From: Chris Moore [REDACTED]
Sent: 27 July 2021 10:22
To: Iqraa Malik
Cc: Planning; Mr Rishman
Subject: FW: Request for further information M/86/21/HH
Attachments: M_86_21_HH202107261157159756.pdf; Site Plan 1.pdf

SITE PLAN - 1/500

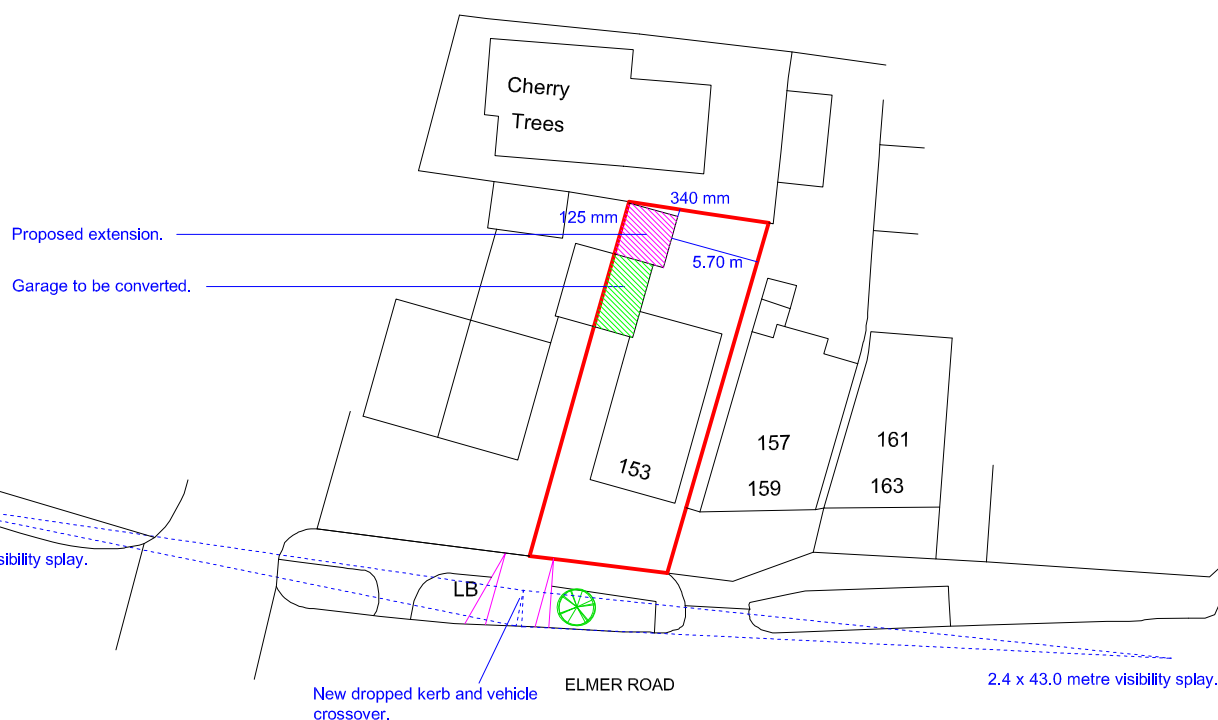
1. Visibility splays - A splay is formed for a 30 mph speed limit road by measuring from a point 2.4m back from the kerb edge in the centre of the proposed access. A line should then be drawn from either side of this point for 43 m in each direction to the nearside edge of the carriage way. The splays must intersect land only within the control of the applicant, or within the publicly maintained highway.
2. Garage to be converted.

I attach a copy of a revised site plan showing:-
